Sizewell C (SZC)

Planning Inspectorate Reference: *EN010012*

Written summary of oral case

ISH 5 Landscape and Visual Impact and Design, 13 July 2021

**DRAWING TITLE:**  
 PILLBOX FIELD PROPOSED LANDSCAPE PLAN

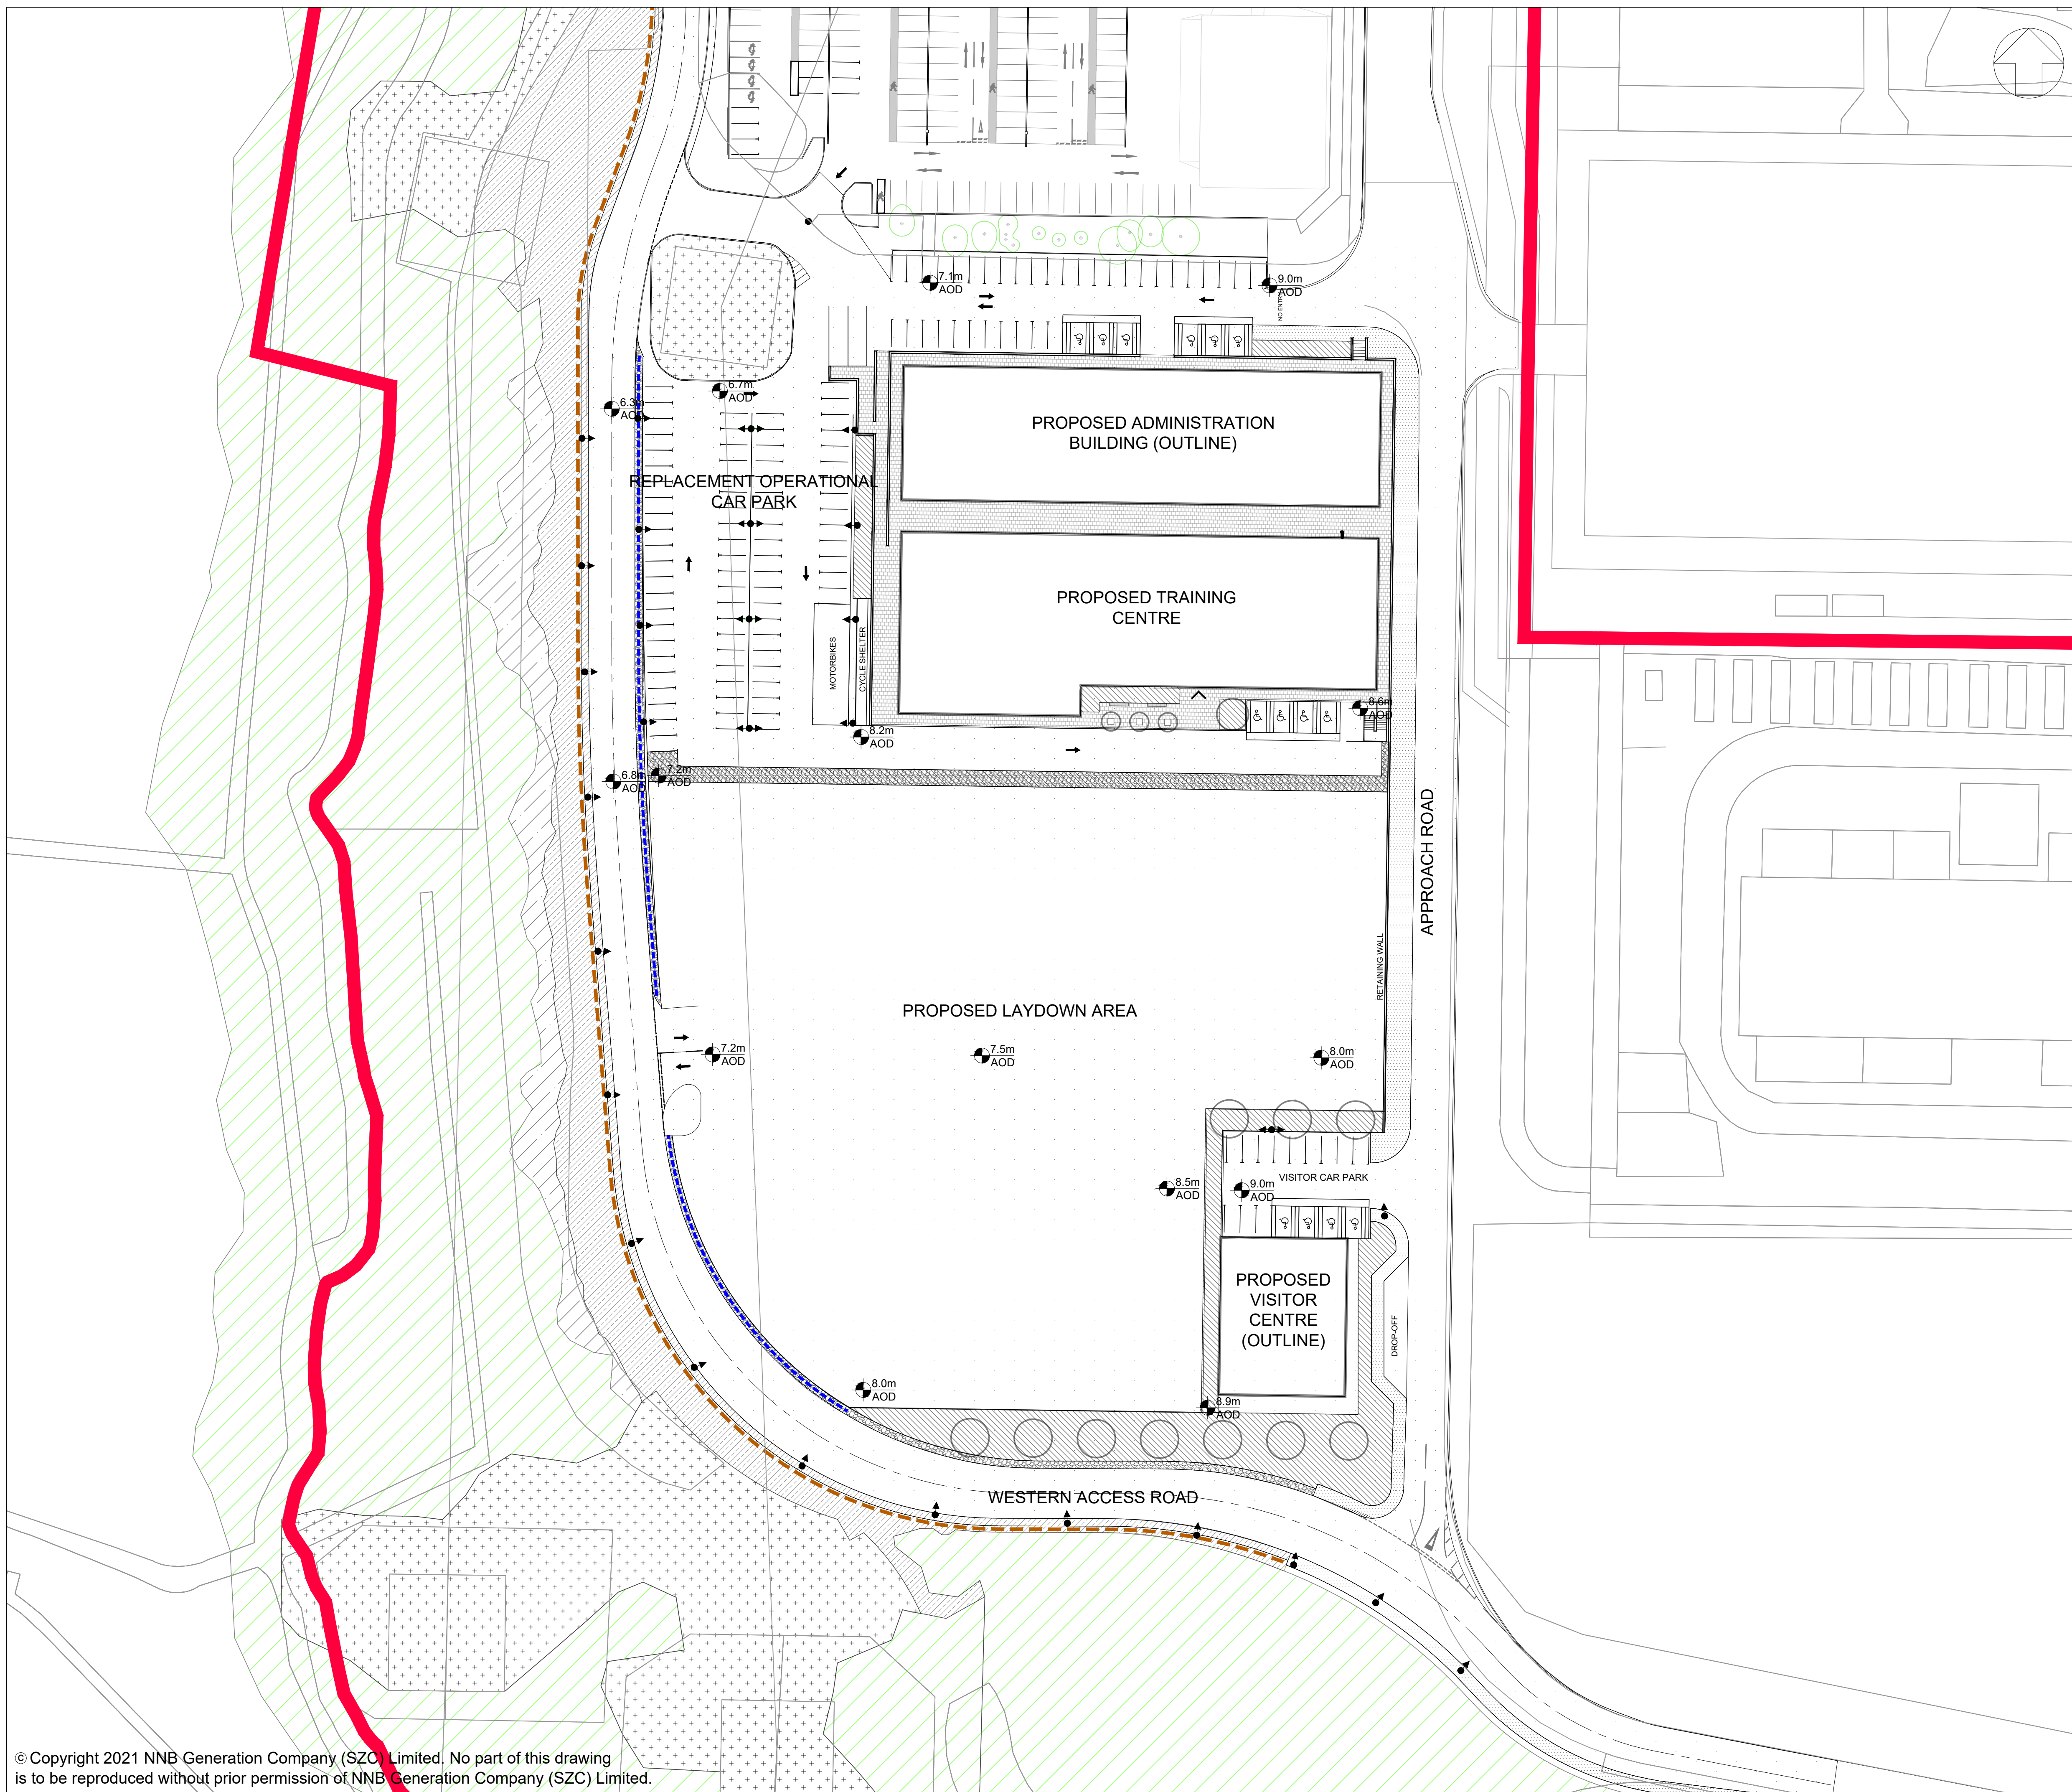
<p>locations• Effectiveness of landscaping proposal in Pillbox field</p> <ul style="list-style-type: none"> • Monitoring and mitigation 	<p>There is a symmetry in the layout of the set piece buildings on the Island and their use of a vertical ordering of facades, incorporating the language of plinths, for example, and a hierarchy of scale. The geometric configuration of the layout and composition of buildings is translated into the geometry of their applied appearance, creating symmetry in design. The degree of consideration applied here is welcome and reflects both the Over-arching Design Principles in relation to being a master-planned composition and the intentional broad symmetry in plan form.</p> <p>The design of the Operational Services Centre building shows a refined and sophisticated approach with depth of thought and consideration applied to ensure a good design outcome.</p> <p>The design of the main access building is overly-utilitarian for a structure that acts as a gate lodge at the entrance to the main development site (LIR paragraph 14.25 [REP1-045]).</p> <p>There are still areas to be agreed in relation to the detailed design of the MDS. The cladding, the size of shadow gap, grid of smaller and larger shadow gaps, edge treatments at corners, parapets, and junction with the plinth storey are all areas of detail that are yet to be agreed (LIR paragraph 14.16 [REP1-045]).</p> <p>The detail of the use of glass fibre reinforced concrete panels for the plinth storeys to the turbine halls and OSC building is yet to be agreed in relation to colour and texture.</p> <p>Ancillary Buildings</p> <p>The proposed design of the ancillary and plant buildings will employ the use of a darker cladding finish and ESC is satisfied that this would allow these buildings to be visually cohesive with the wider operational platform (LI.1.35 [REP2-176]).</p>
